# ***City of Albuquerque***

**RE: GRADING & DRAINAGE PLAN FOR ALAN REGIS (J-14/D134)  
RECEIVED AUGUST 3, 1999 FOR BUILDING PERMIT  
ENGINEER'S STAMP DATED 07-27-99**

A PROPOSED GRADING & DRAINAGE PLAN
FOR AN OFFICE/WAREHOUSE DEVELOPMENT FOR
ALAN & FRANCINE REGIS
ALBUQUERQUE, NEW MEXICO
JULY, 1999

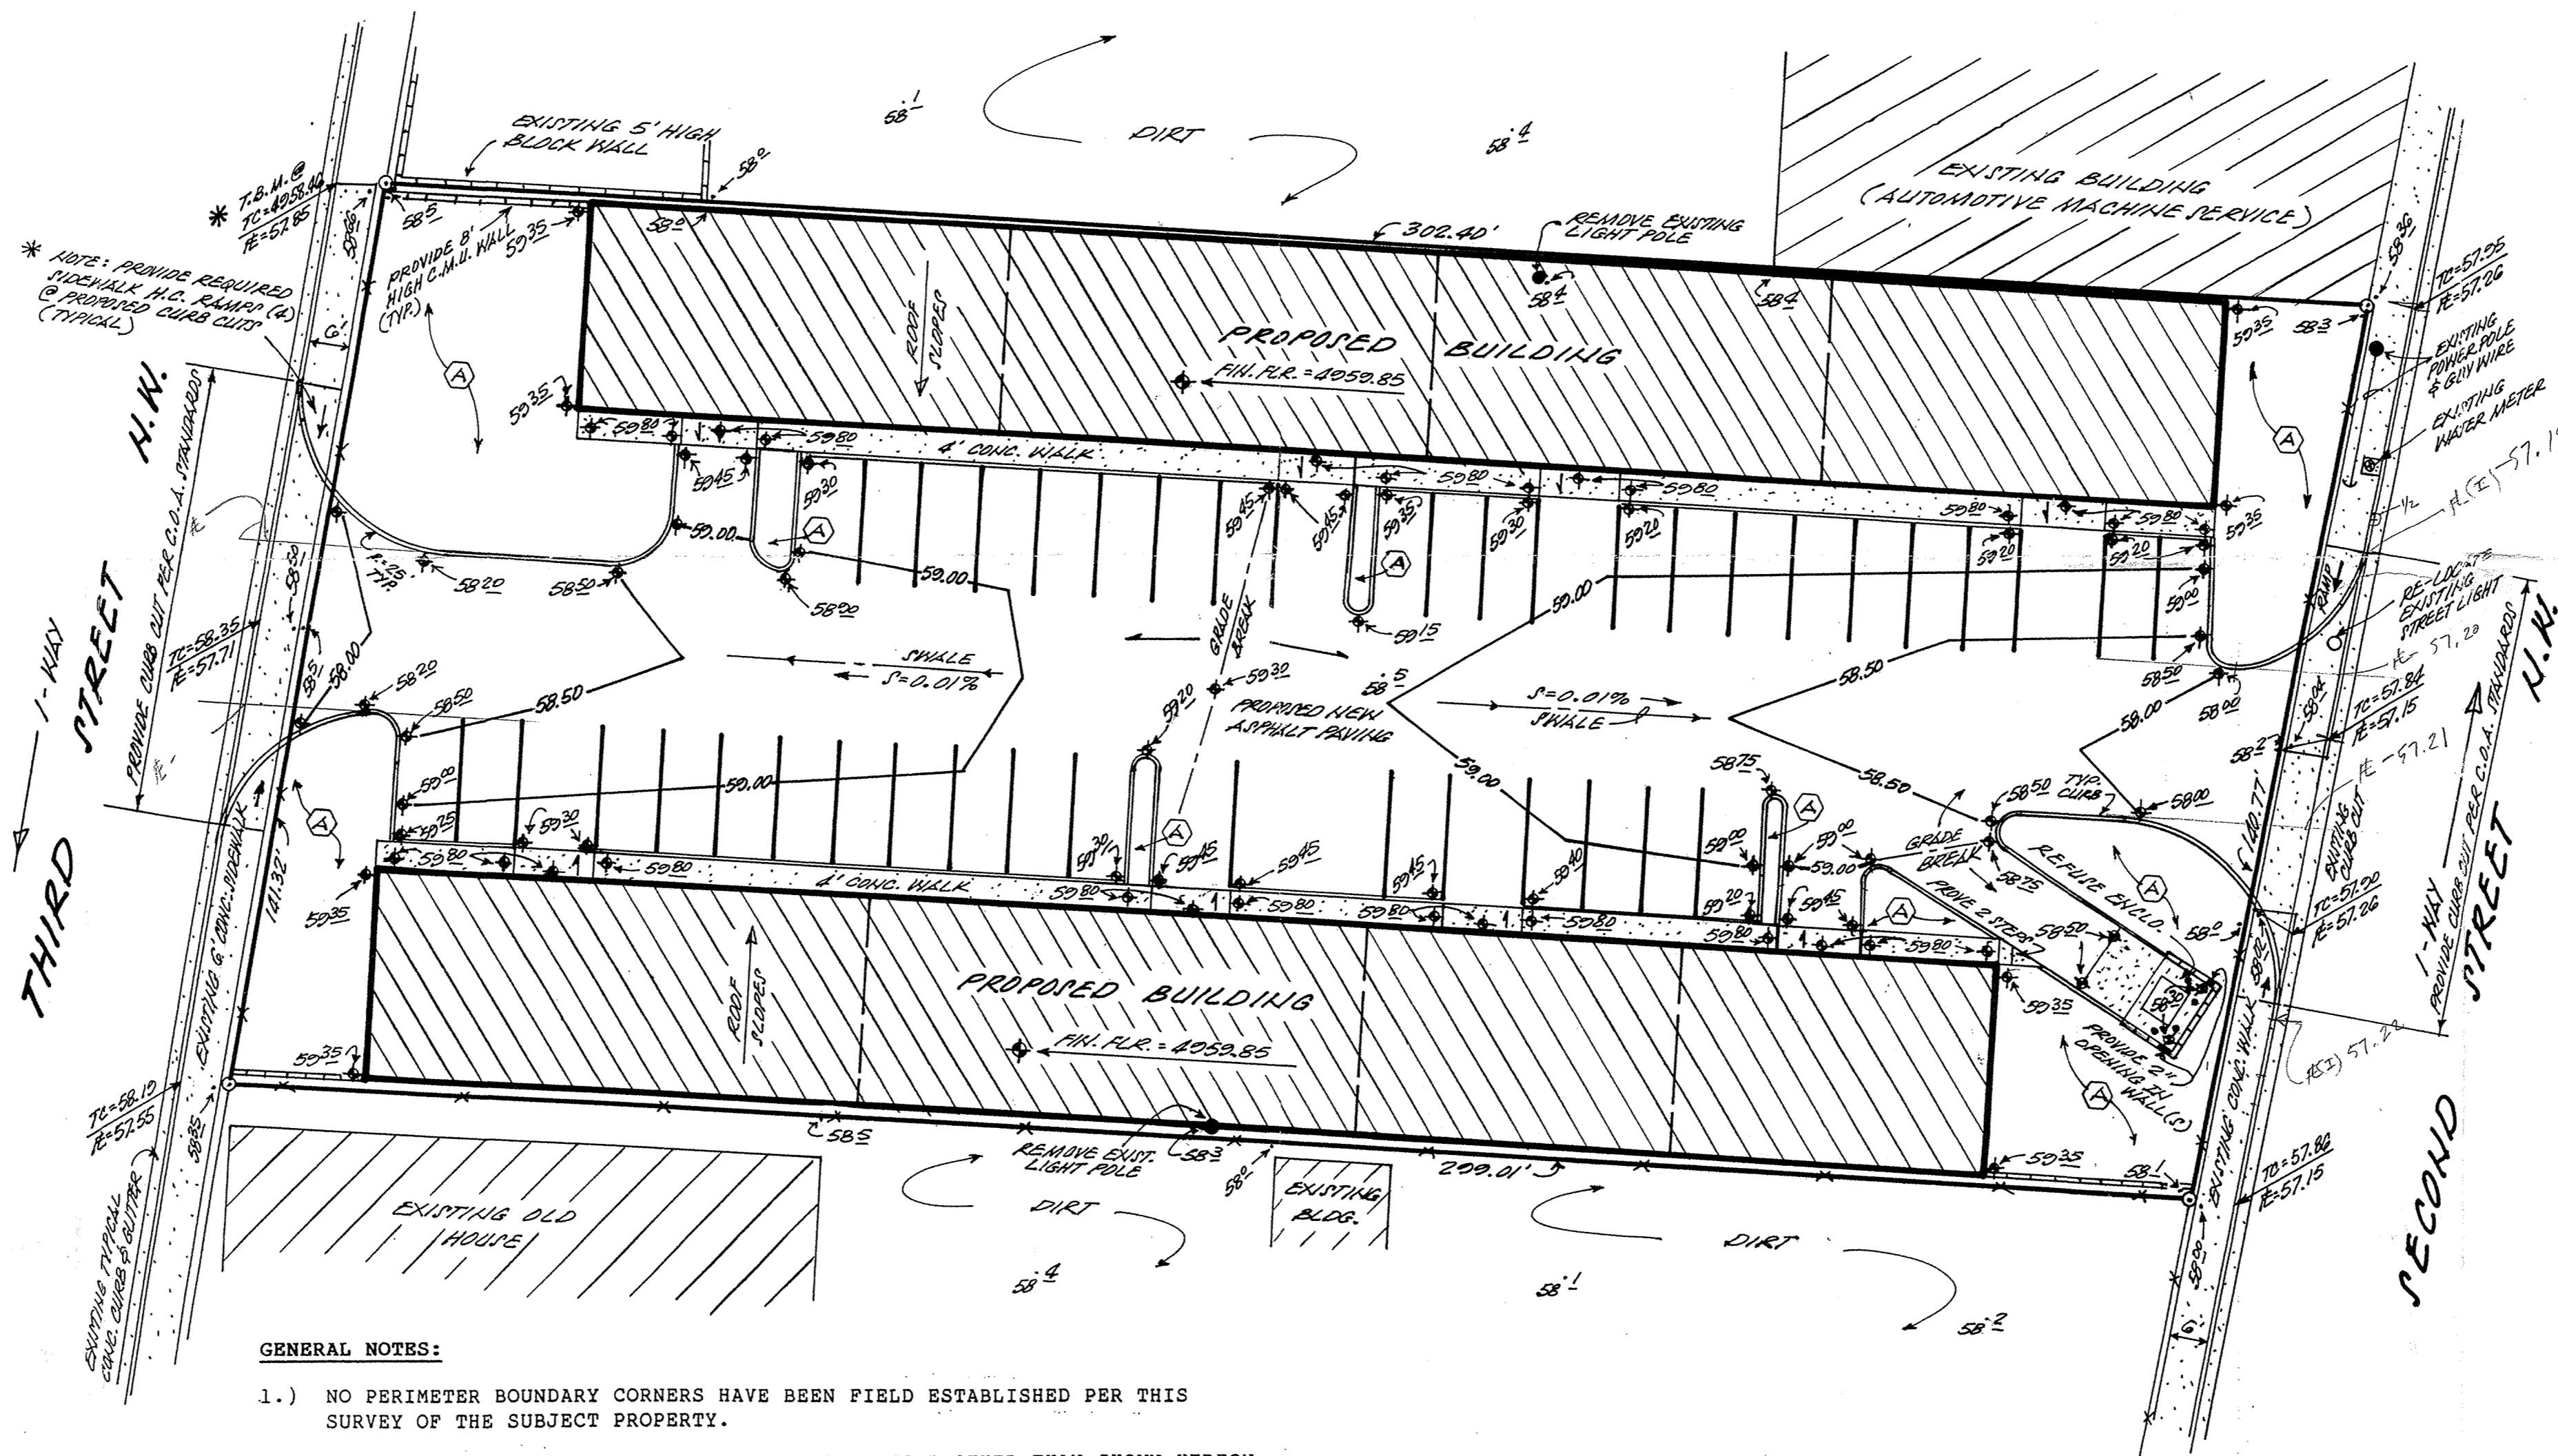
This is an infill site. Analyze the two basins separately. A 42% increase in discharge is significant. Calculate the existing & proposed runoff volume. Provide detention ponds with storage volume greater than the increase in runoff volume. If a S.O.19 permit is required, then an additional copy of the Grading & Drainage Plan must be submitted for transmittal to the sidewalk inspector.
